July 6, 2022

**WEC RESPONSES – 8/8/22**

**RE: Trailer Direct Express Rezone and Site Plan 2<sup>nd</sup> Submittal**

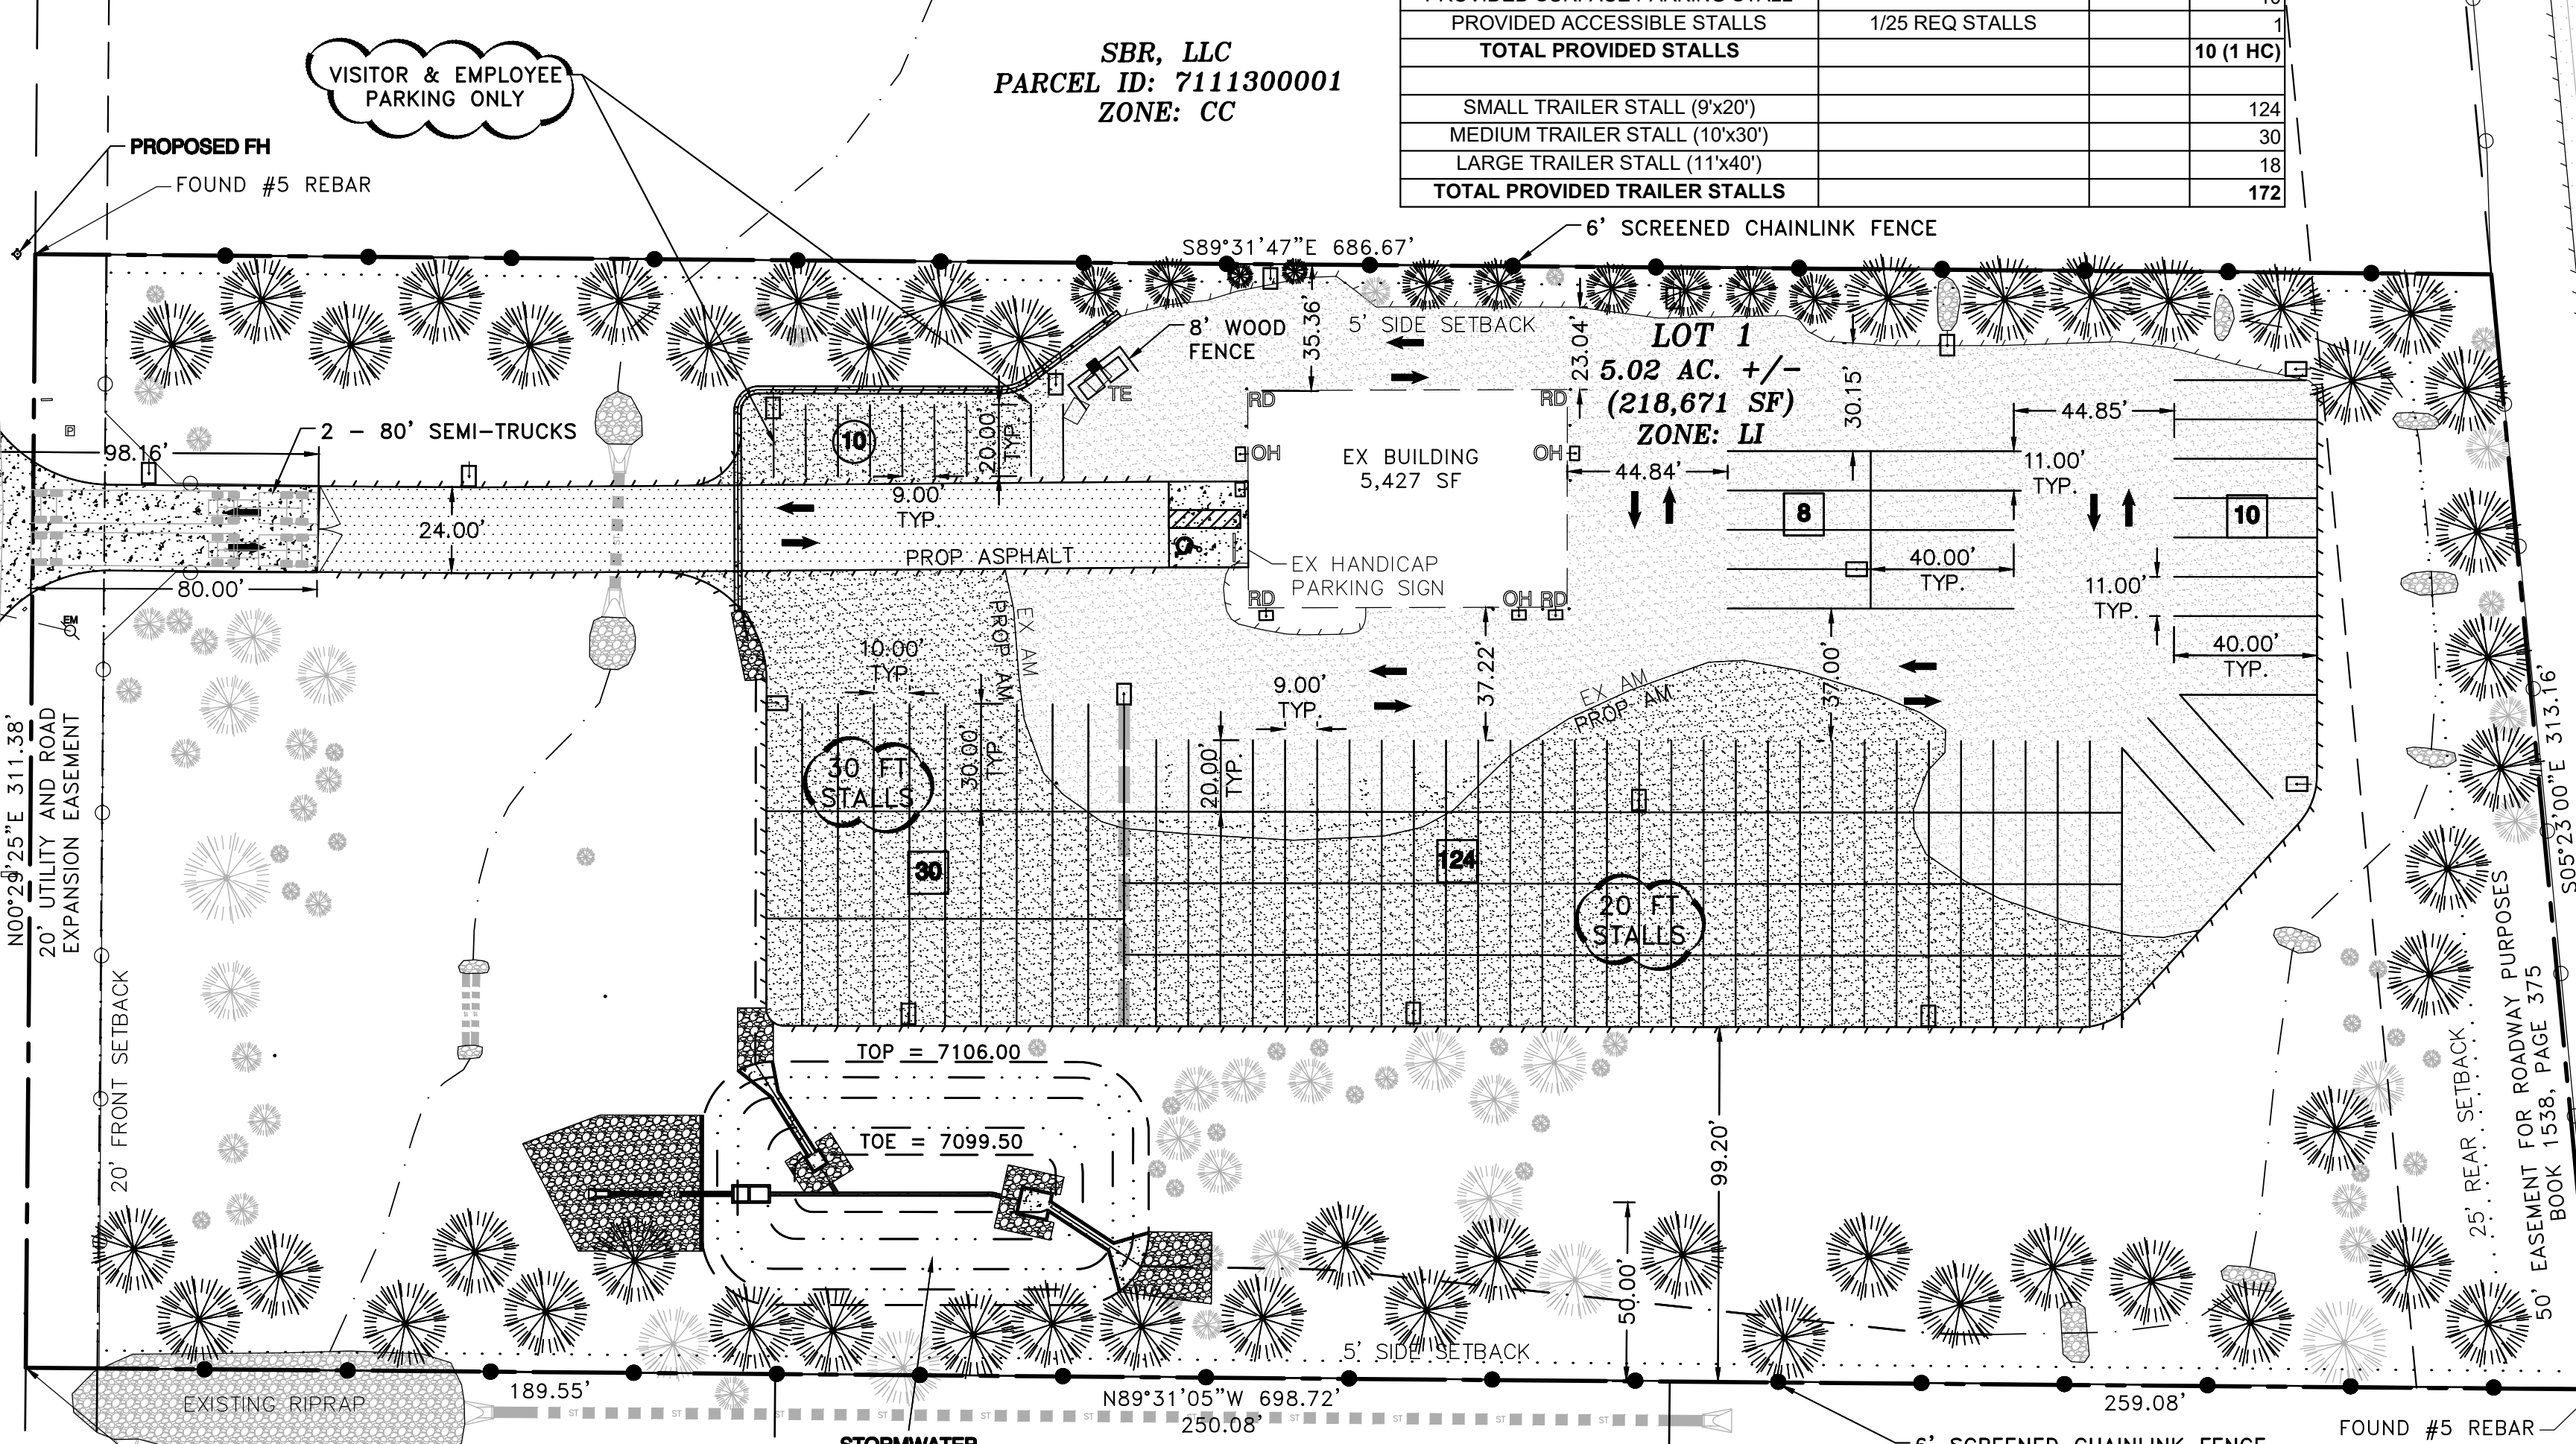
1. Existing utilities in Beacon Lite Road right-of-way should be shown. **Addressed**

2. Driveway culvert size and material should be shown. **Addressed**

3. On-site water and sanitary sewer lines are identified with "Proposed" legend line types ("WAS" and "SS"). These are identified elsewhere as existing. Please clarify. **Addressed**

4. Will there need to be any demo or reconfiguration of the chain link fence in the vicinity of the detention pond outlet/spillway? **Addressed**

5. There appears to be an end section and pipe leaving the riprap swale at the southwest corner of the site. Pipe size and type should be provided, as well as any known discharge location. **Addressed**

6. The watercourse running from north to south through the western portion of the site is identified on National Wetland Inventory (NWI) as a freshwater emergent wetland (PEM1C). Please comment on any historic delineations or resolutions of wetland impacts. **Addressed**

GRADING PLAN
TRAILERS DIRECT EXPRESS
18955 BEACON LITE ROAD
TOWN OF MONUMENT, EL PASO COUNTY, COLORADO

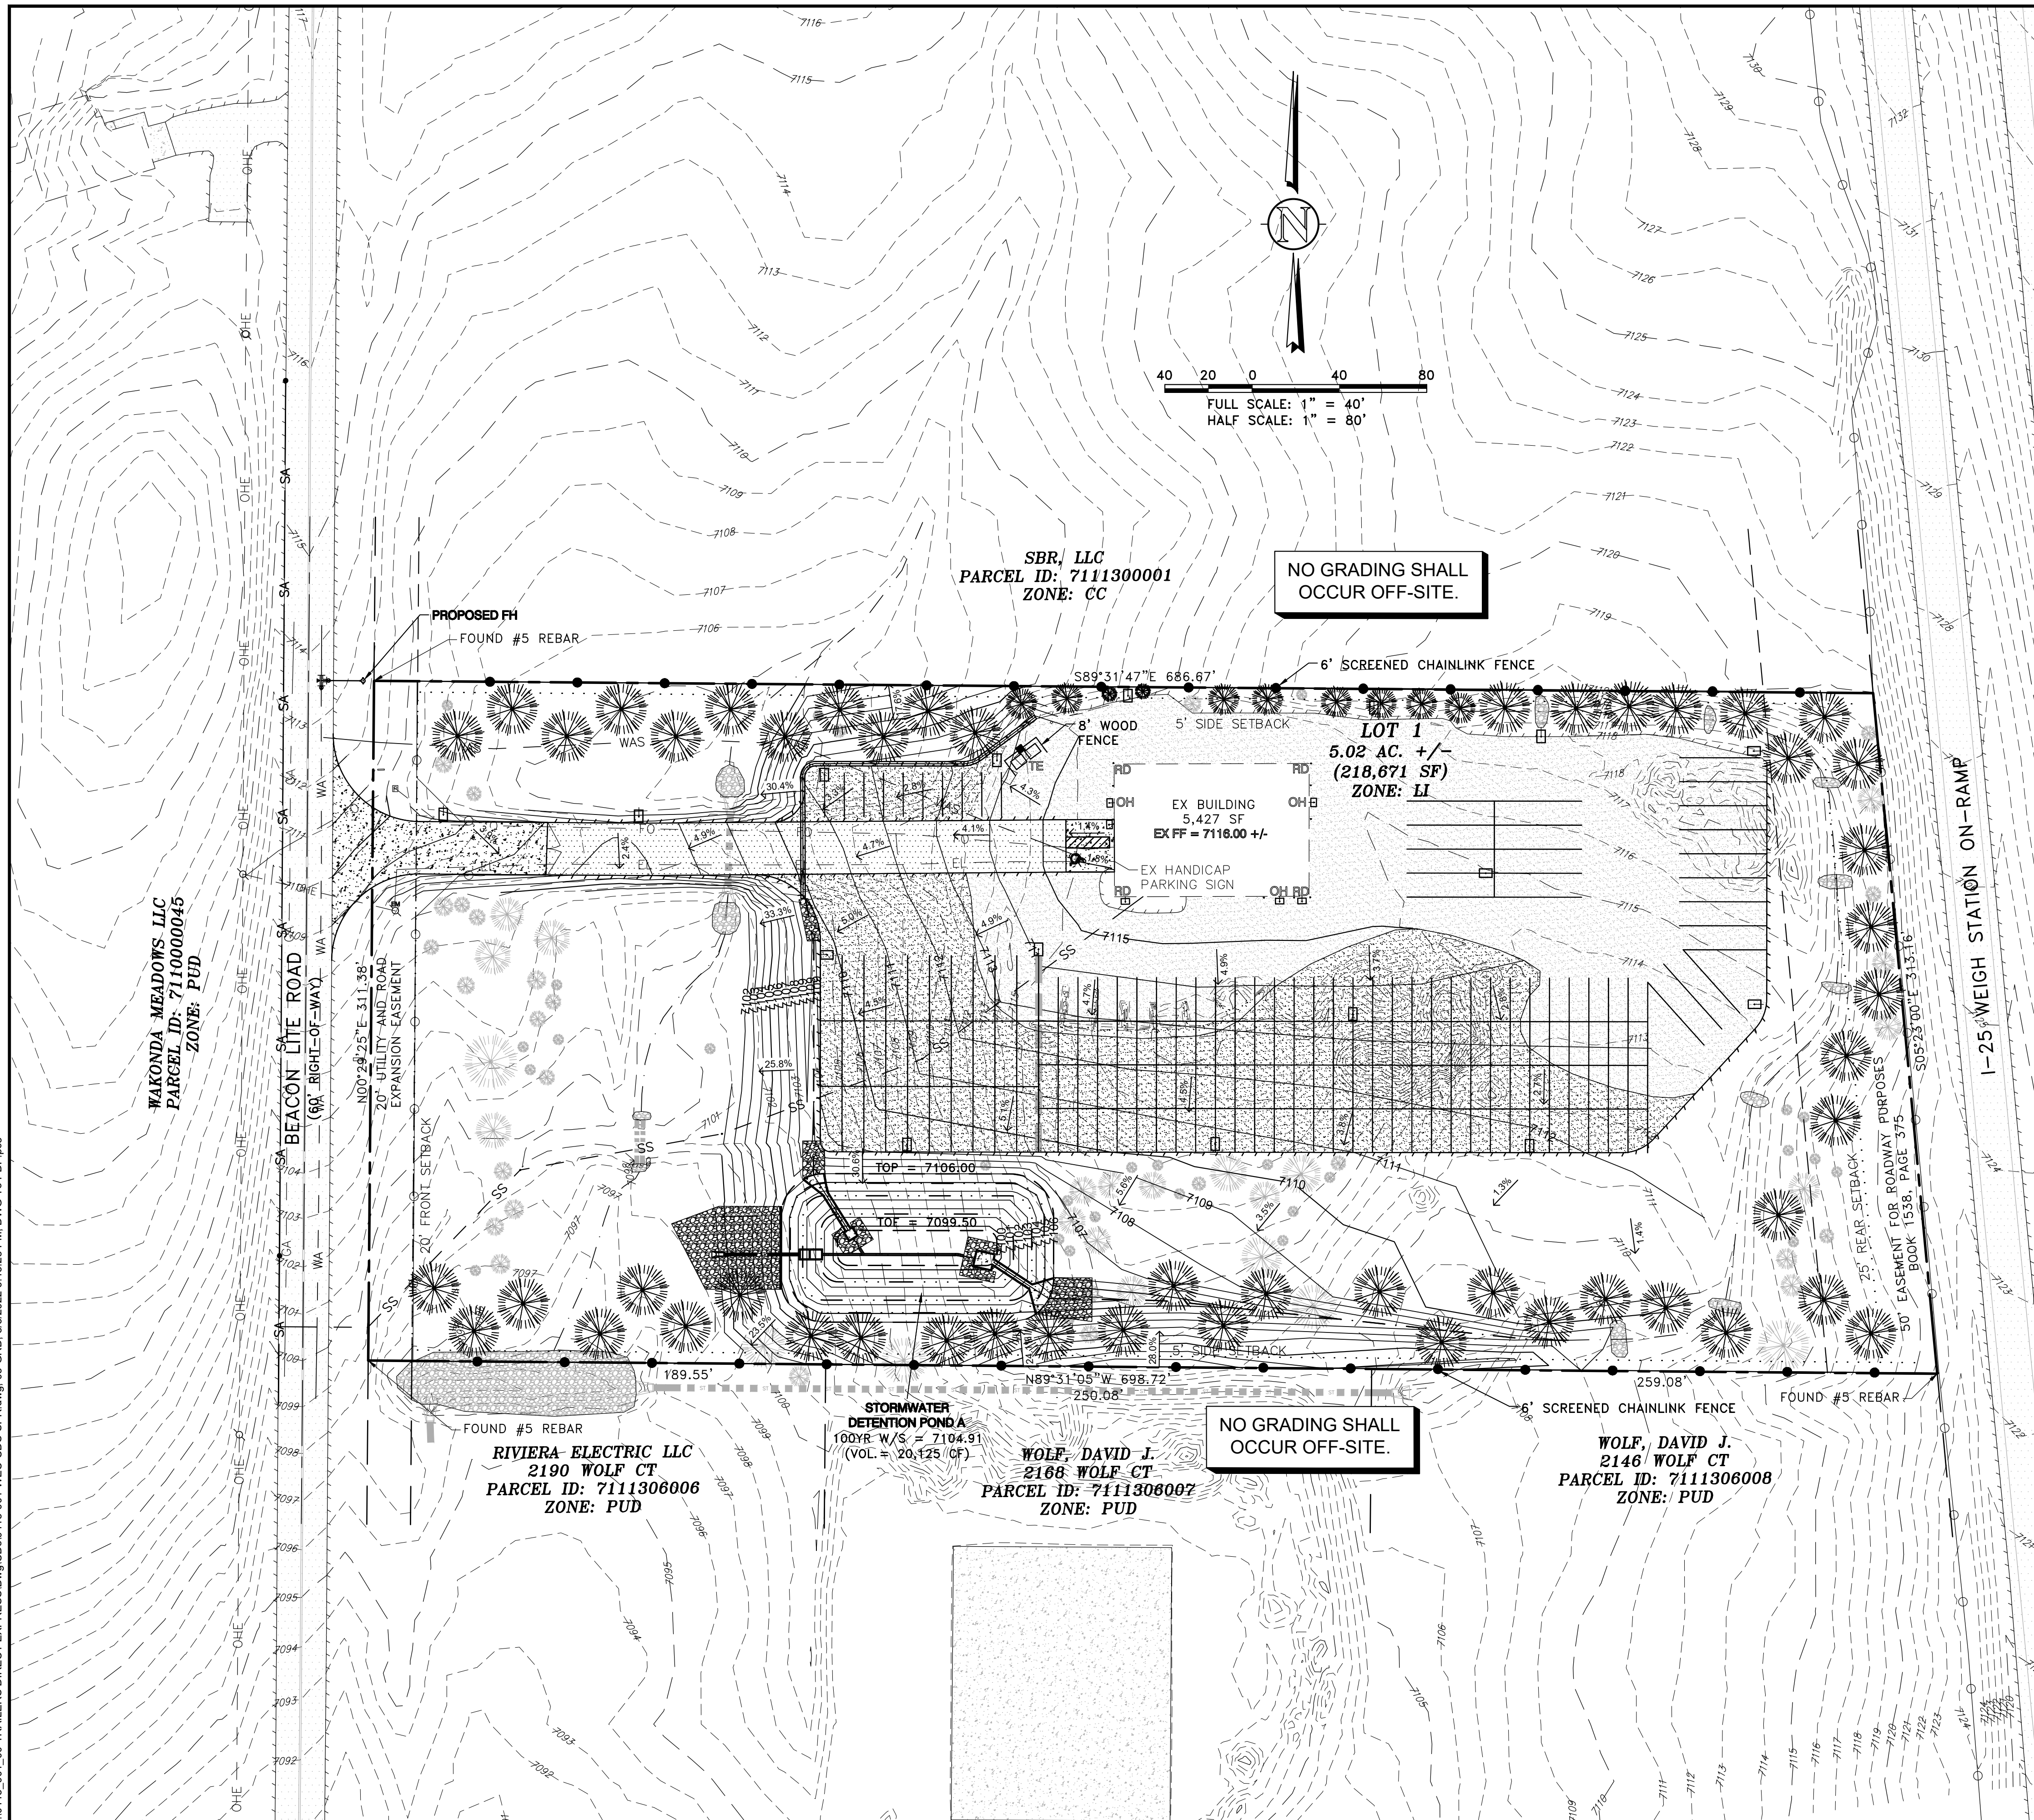
1. Several proposed/relocated trees are shown in the center of the proposed ditch along the southern property boundary and should be moved. **Addressed**

2. A note in the Grading Legend indicates grading is to be constructed per shown spot elevations. No spot elevations are provided; however, they are provided on detailed grading plans contained in the Final Drainage Reports as Sheets 8 and 9. It is recommended that the grading sheets be made part of the Site Plan set and removed from the Drainage Report. Similarly, the drainage basin sheets can be removed from the Site Plan set and provided solely in the Drainage Report. **Addressed**

3. See Sheet 2 comment regarding the existing watercourse, as swale and pond grading are shown within the NWI wetland mapped area. **Addressed**
